## **Development Facilitation Team (DFT) – Review Comments**

**Project No: PR-2020-004596      Date: 03/27/2024      Agenda Item: #3 Zone Atlas Page: D-10**

**Request: PRELIMINARY PLAT EXTENSION FOR 30 ACRE DEVELOPMENT TO INCLUDE 162 TOWNHOME LOTS, 1 MULTI FAMILY RESIDENTIAL LOT WITH 175 APARTMENT UNITS AND 1 COMMERCIAL LOT WITH A TOTAL OF APPROXIMATELY 21, 955 SQUARE FEET OF BUILDING SPACE. PRELIMINARY PLAT ORIGINALLY APPROVED MARCH 29, 2023 BY THE DRB.**

**Application For: SD-2024-00045-EXTENSION OF PRELIMINARY PLAT (DHO)**

SEE SHEET 3
MATCHLINE

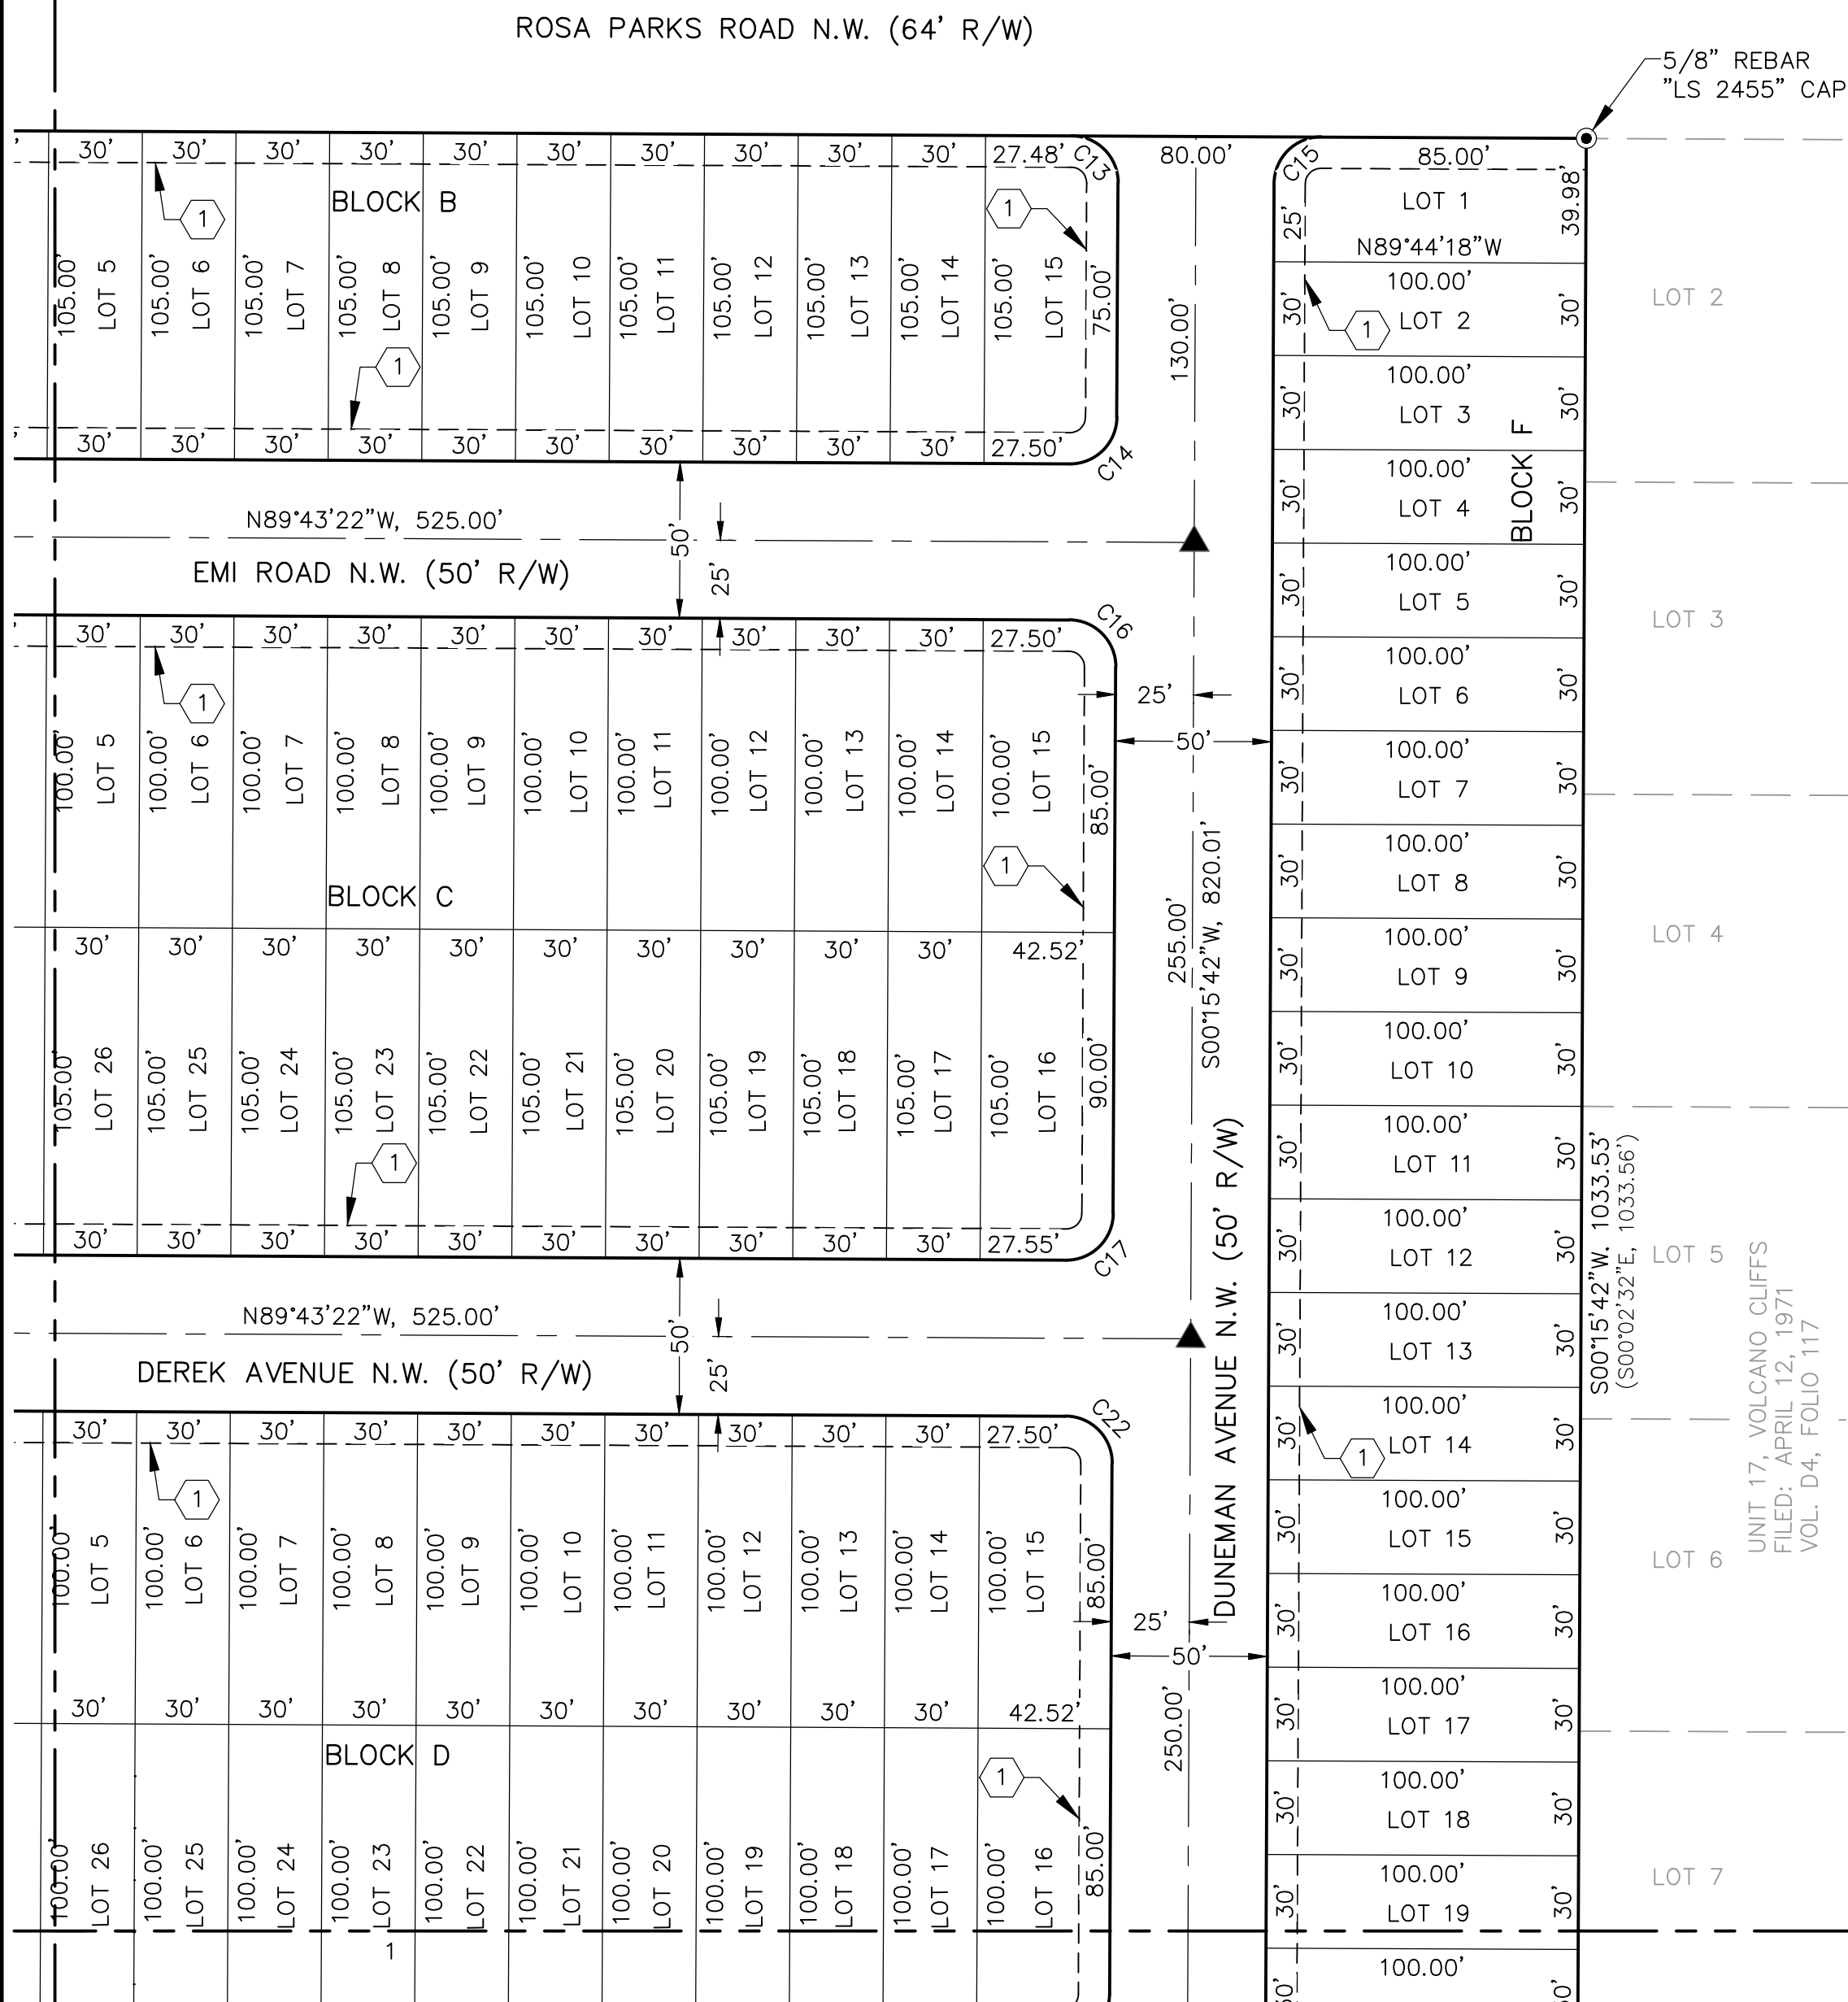
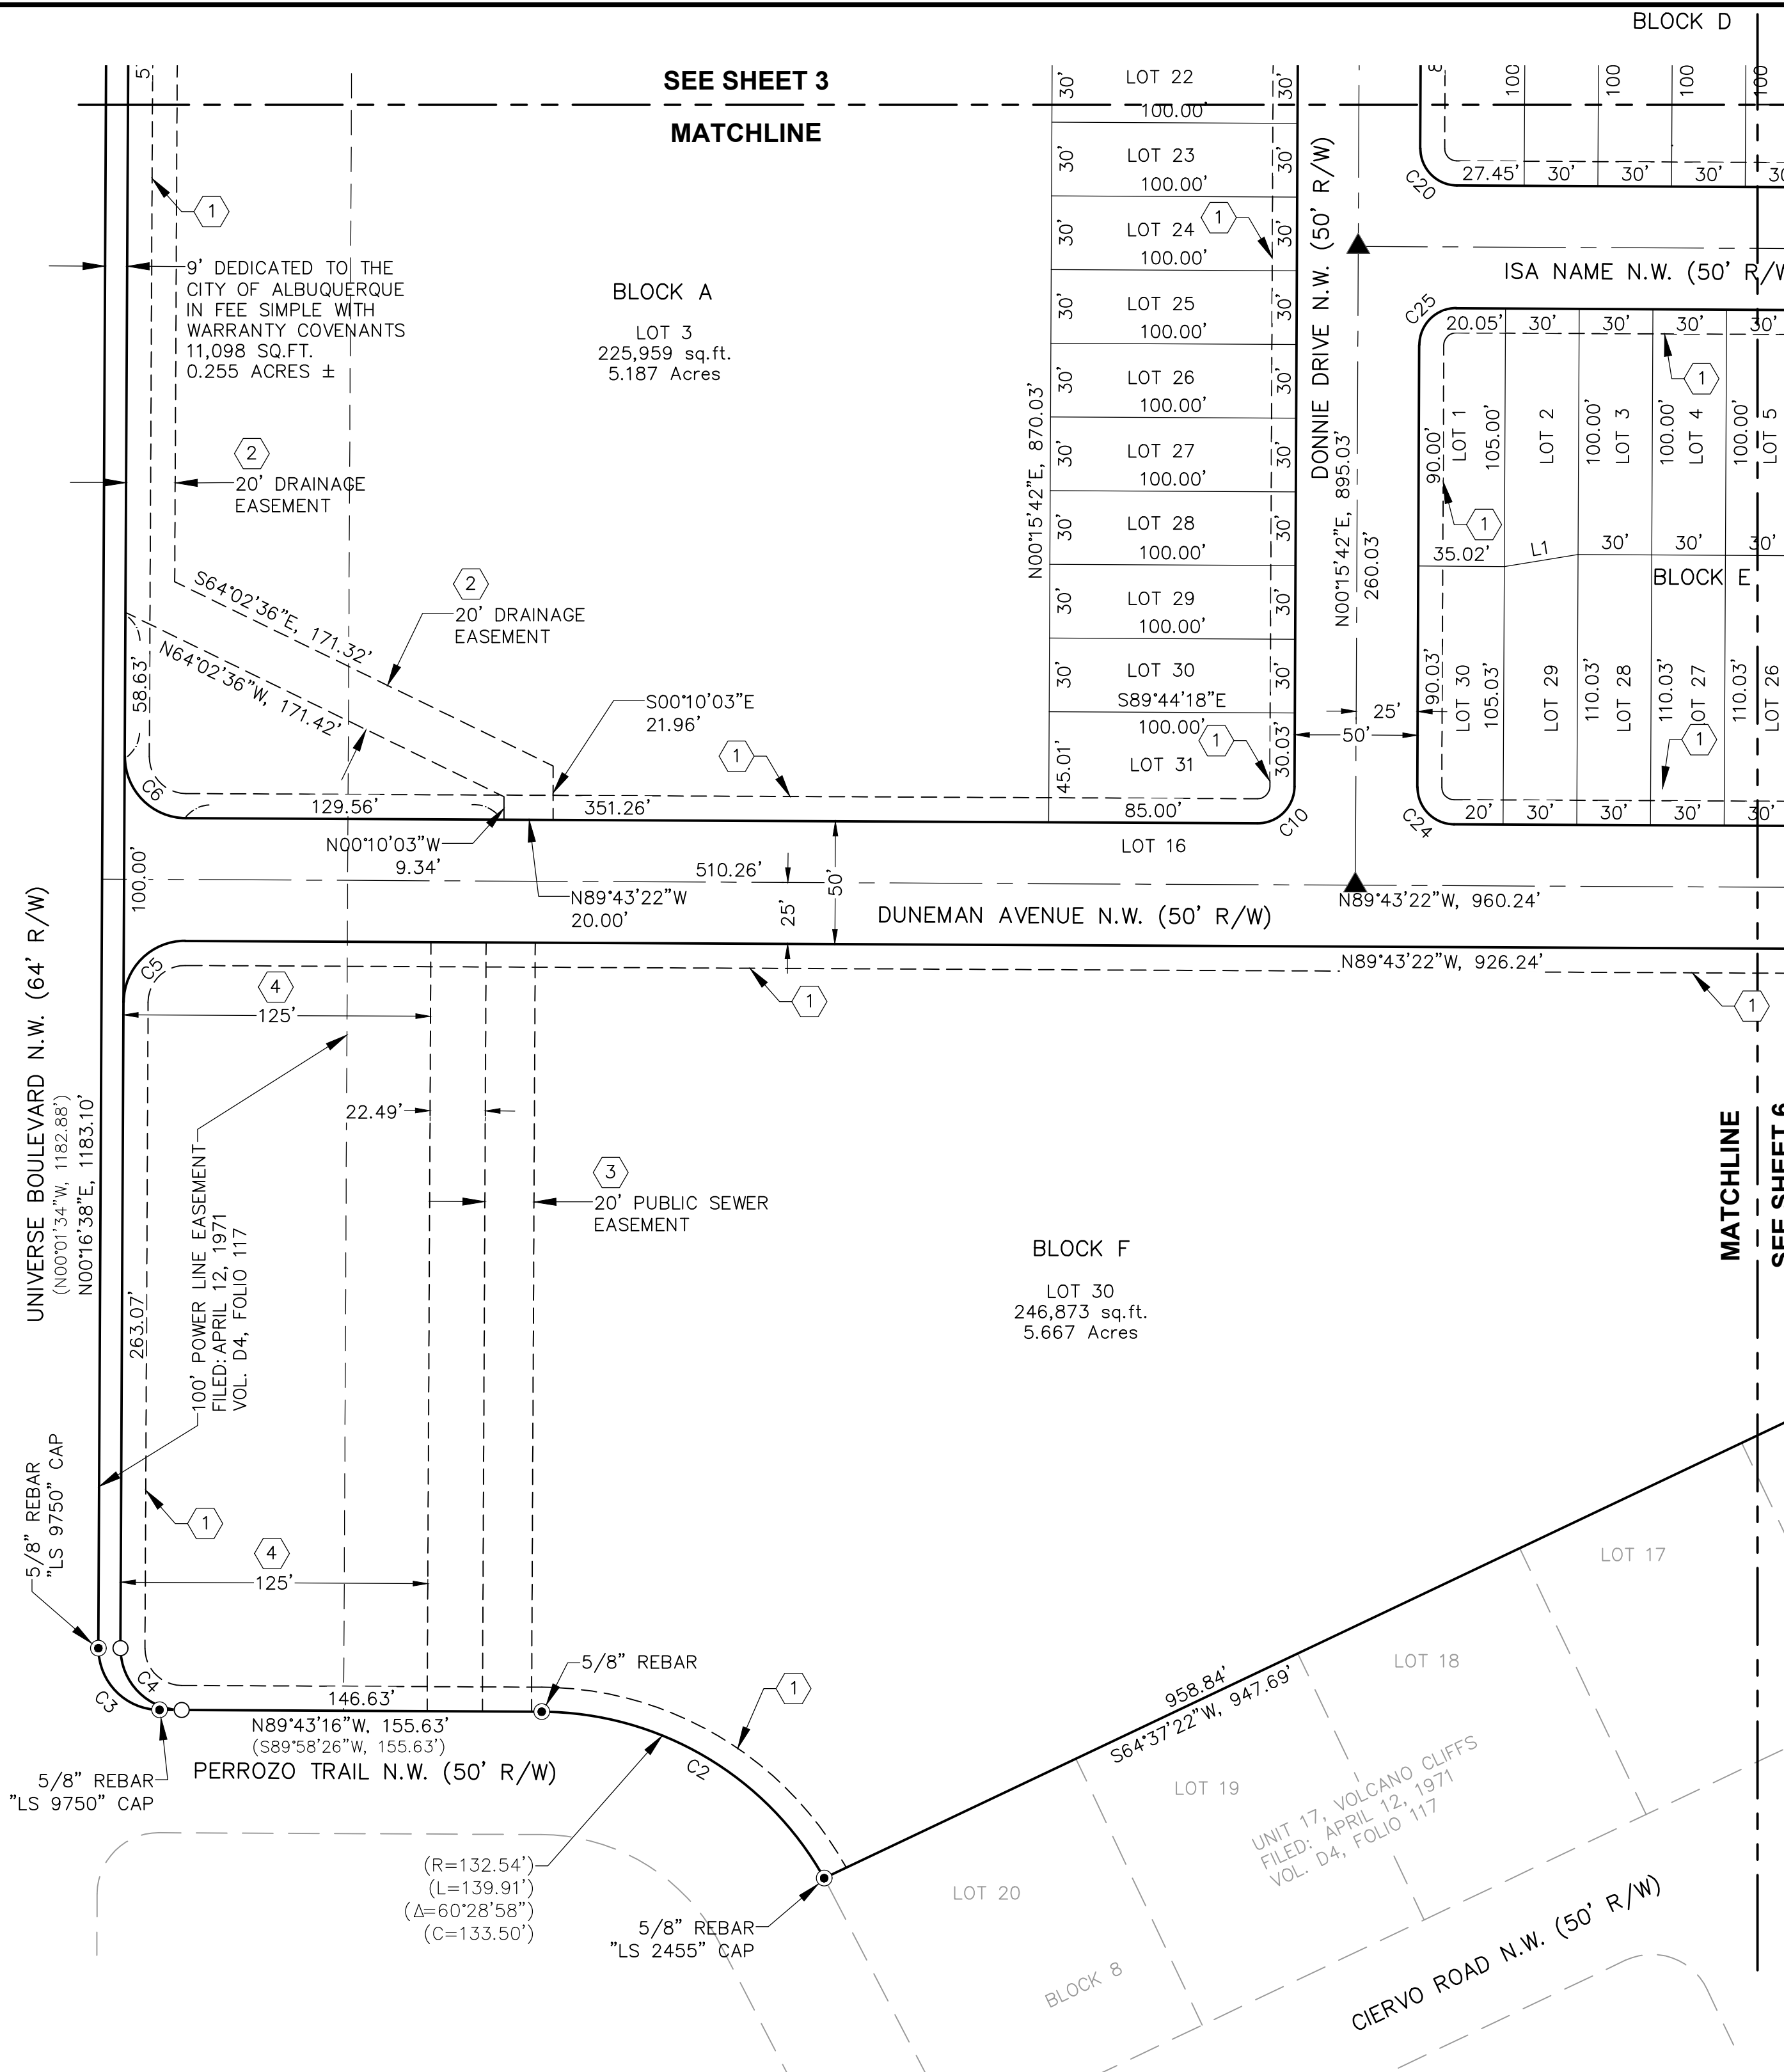
3. **Development** standards of CPO-13 include Façade Design, Building Design, and Garage access limitations (*including rear-load access for townhomes*). It is not clear in this plan that this has been accounted for – please clarify how townhome units in this plan would be accessed.

**Table 5-4-1 limits block lengths on local streets to 600 feet. Block 'F' townhomes is greater than 600 feet. Lots 4 thru 31 create a block greater than 600 feet.**

**5-4(F)(2)(b) Residential lots shall avoid layouts where the rear lot line is adjacent to a collector or arterial street.** Local frontage roads may be used within a subdivision to avoid locating residential rear yard walls along collector and arterial streets. **In the layout presented, rear lot lines are on local streets.**
